3.201 APPLICATION SUBMISSION REQUIREMENTS

The overall purpose of the Northern Delivery System is to ensure Triview and Forest Lakes can maximize the use and reuse of their reusable water. By using and reusing water to extinction the overall need for first use water is reduced. The project utilizes existing infrastructure owned and operated by Colorado Springs Utilities to convey the water from Pueblo Reservoir to the Highway 83 Tank.

1041 Documents Related to 3.201 (Items 1 - 4)_v1 redlines.pdf Markup Summary 12-6-2022

C2
 SHEET --- OF ---

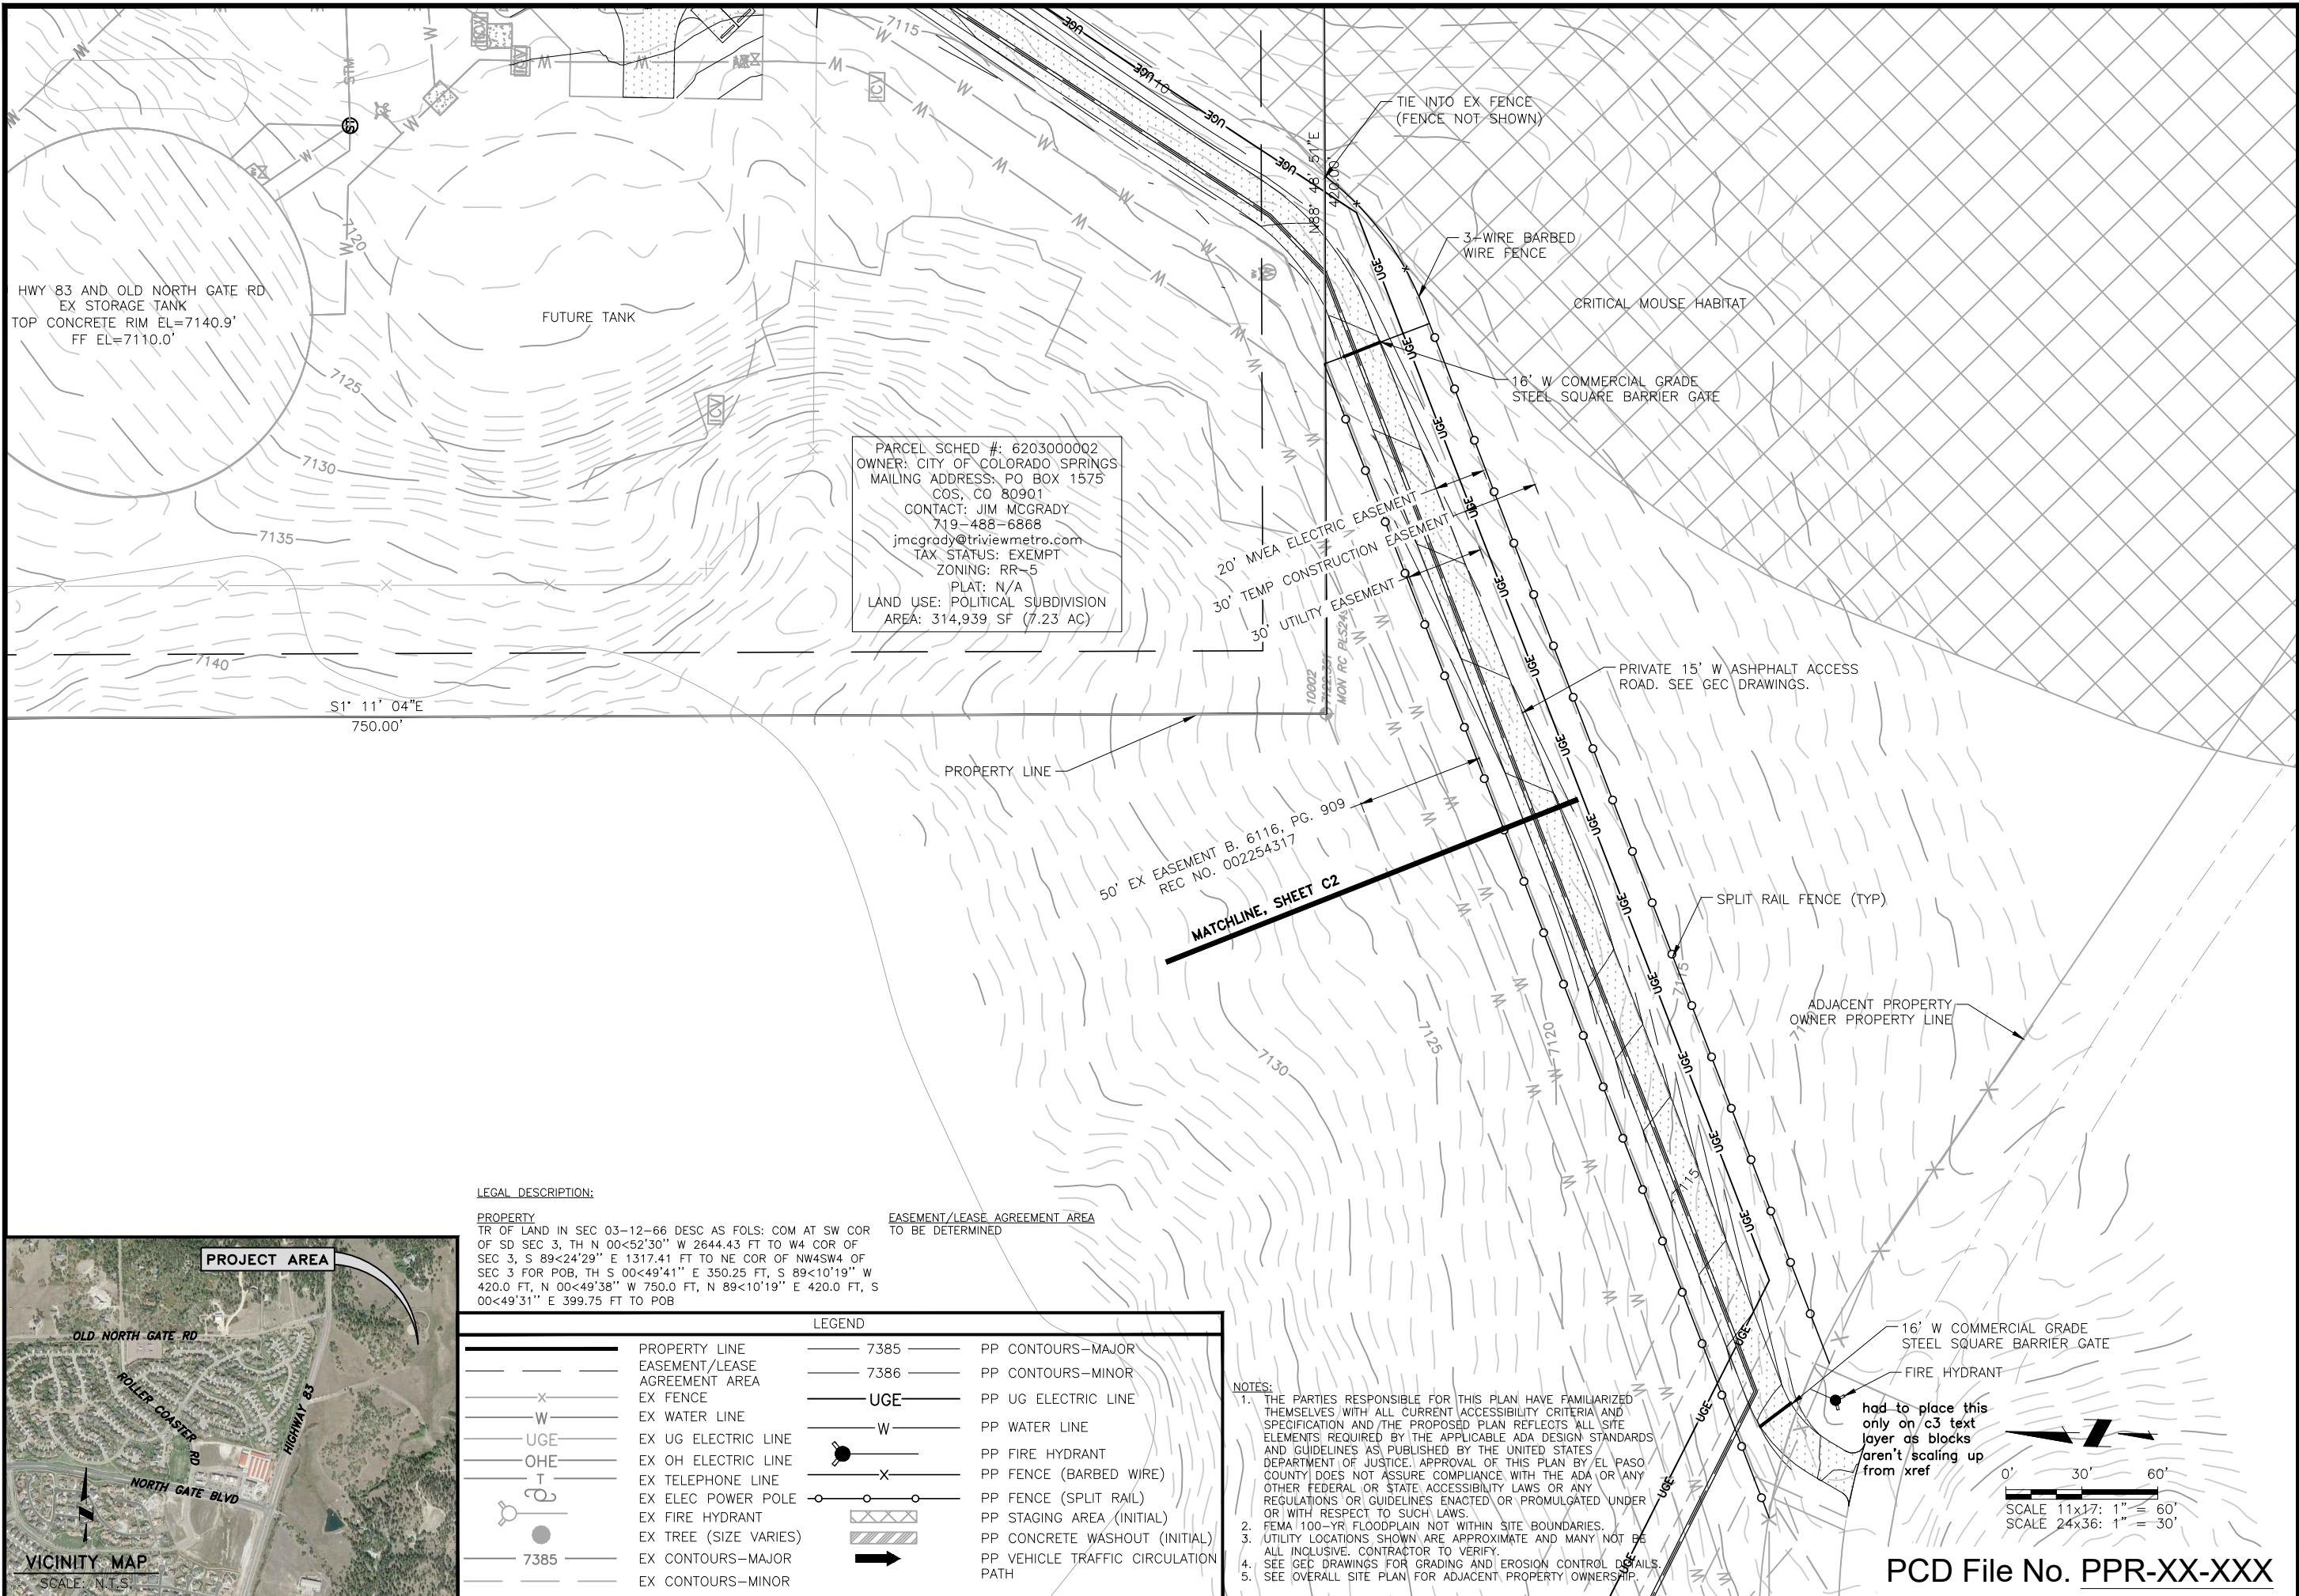
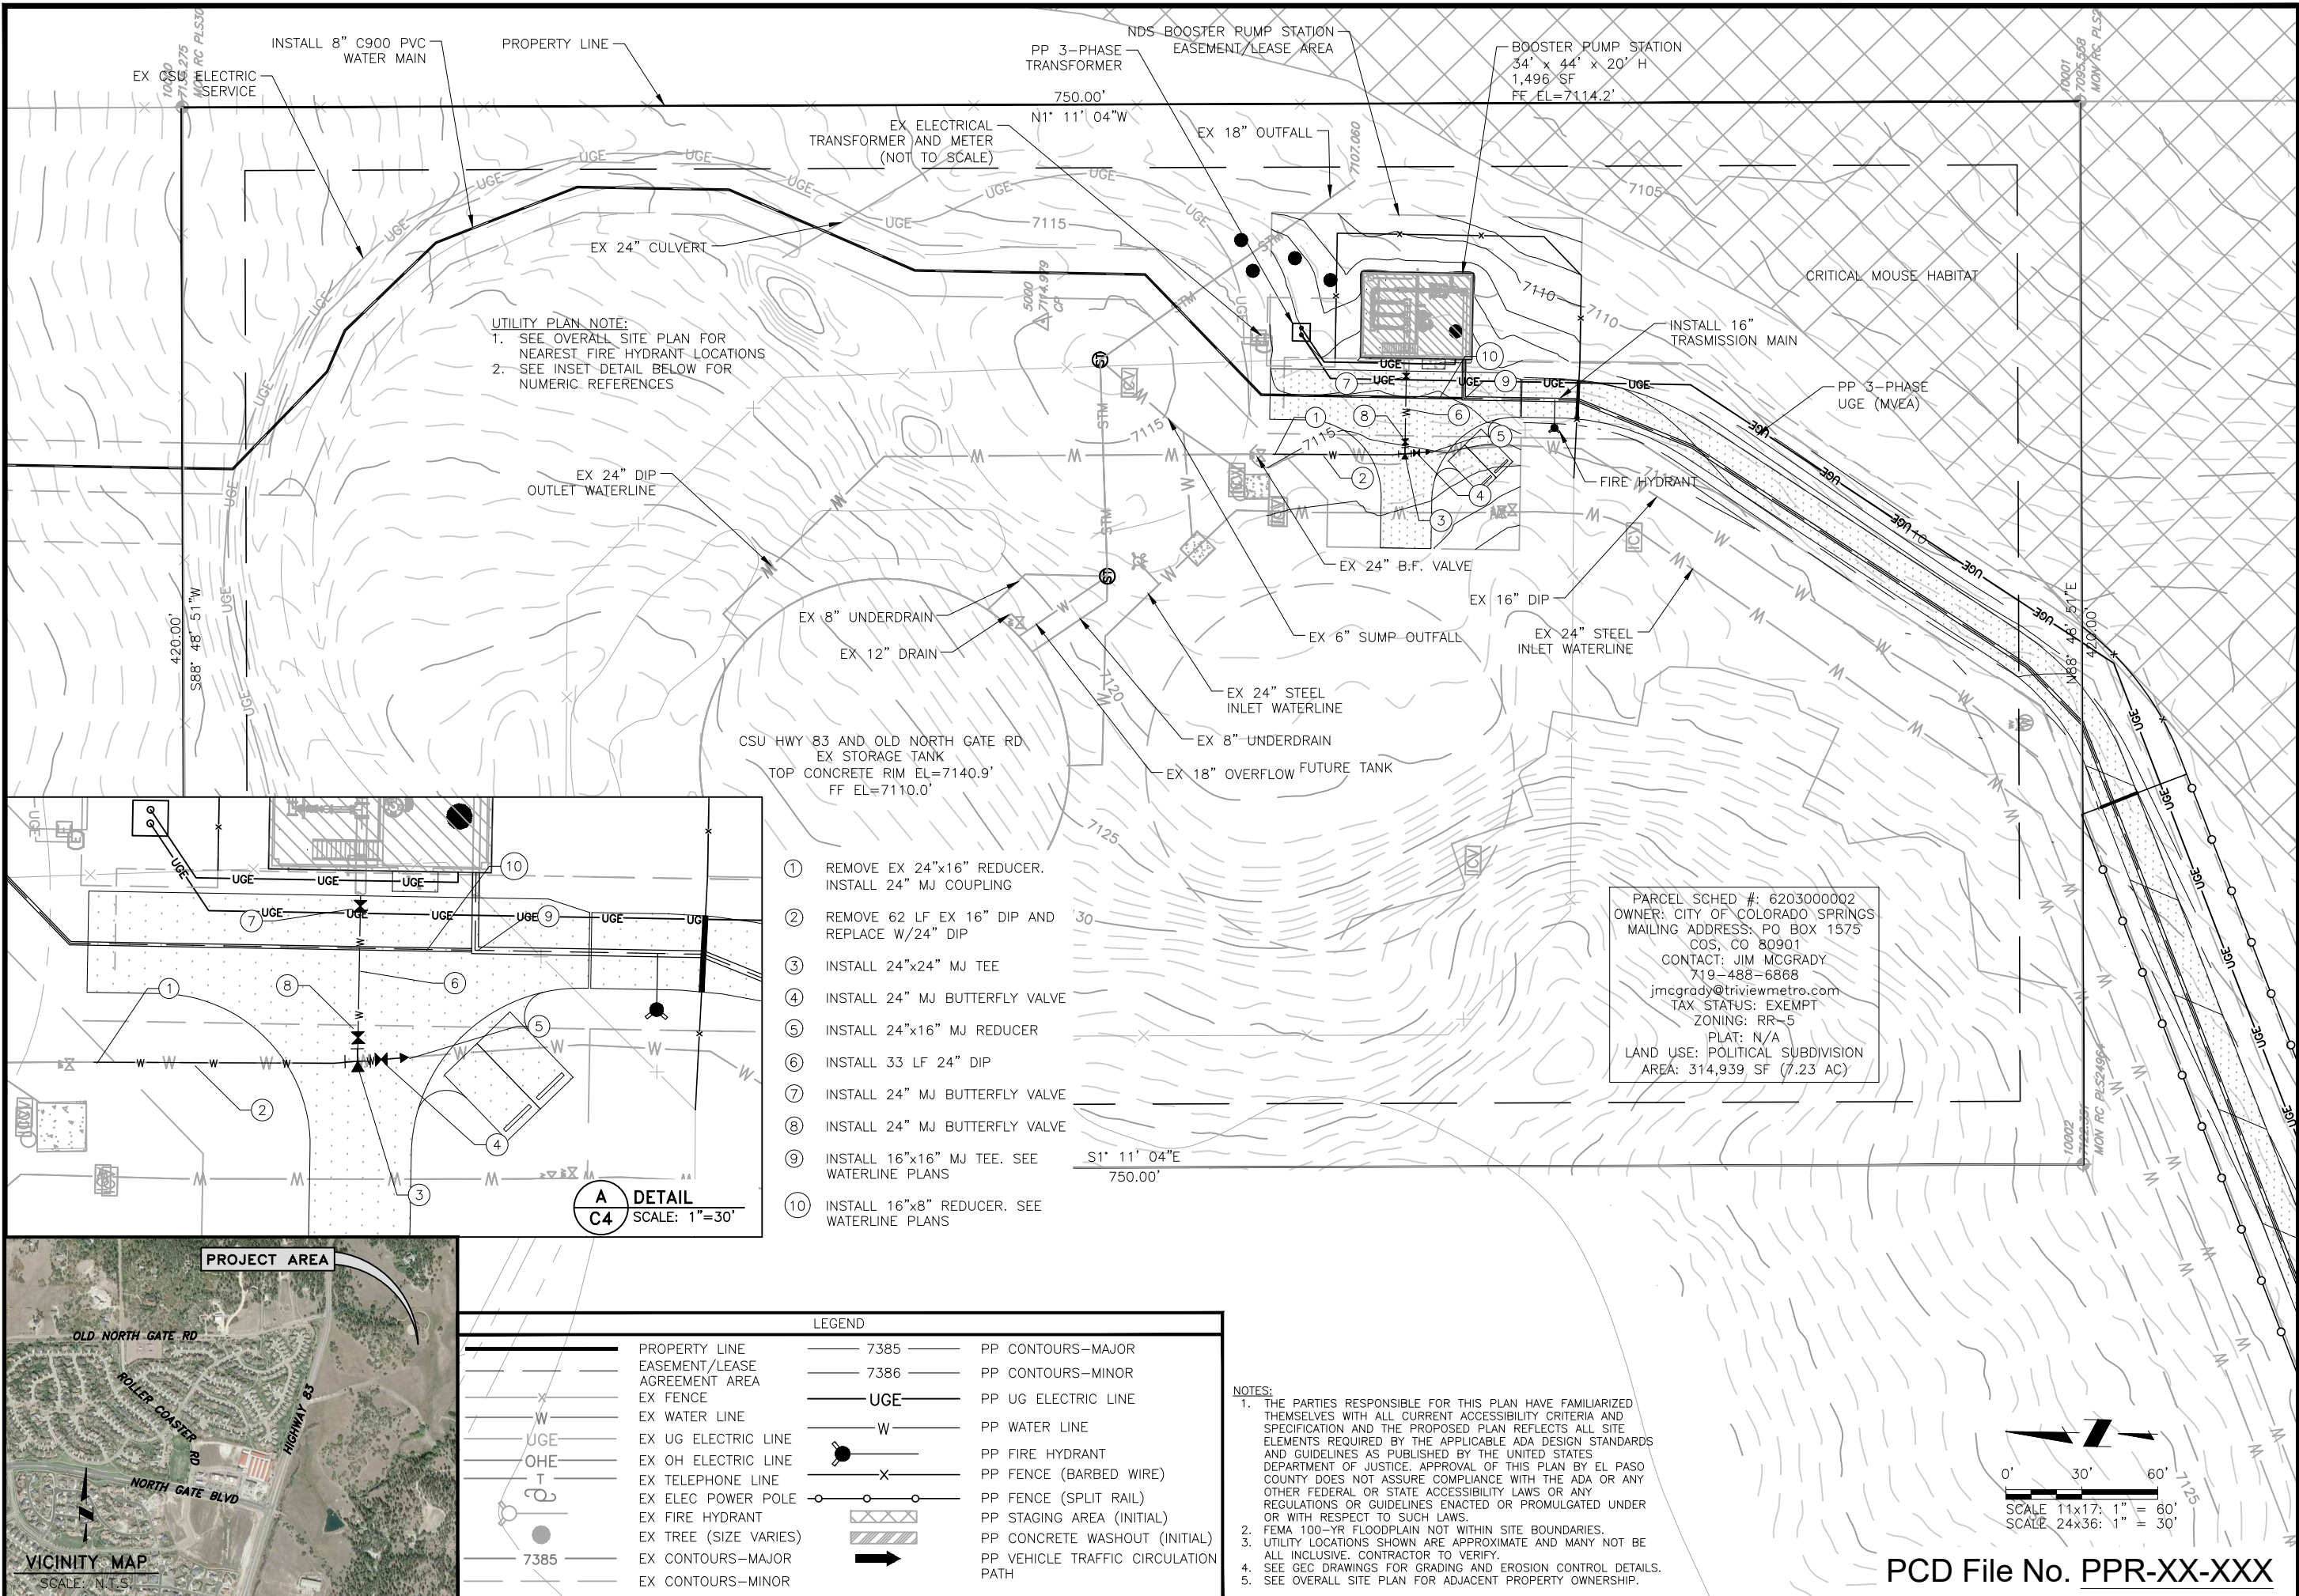
discuss purpose of new tank (overground? size?)

the future tank is depicted on the booster site plan and an additional tank location was discussed in the meetings
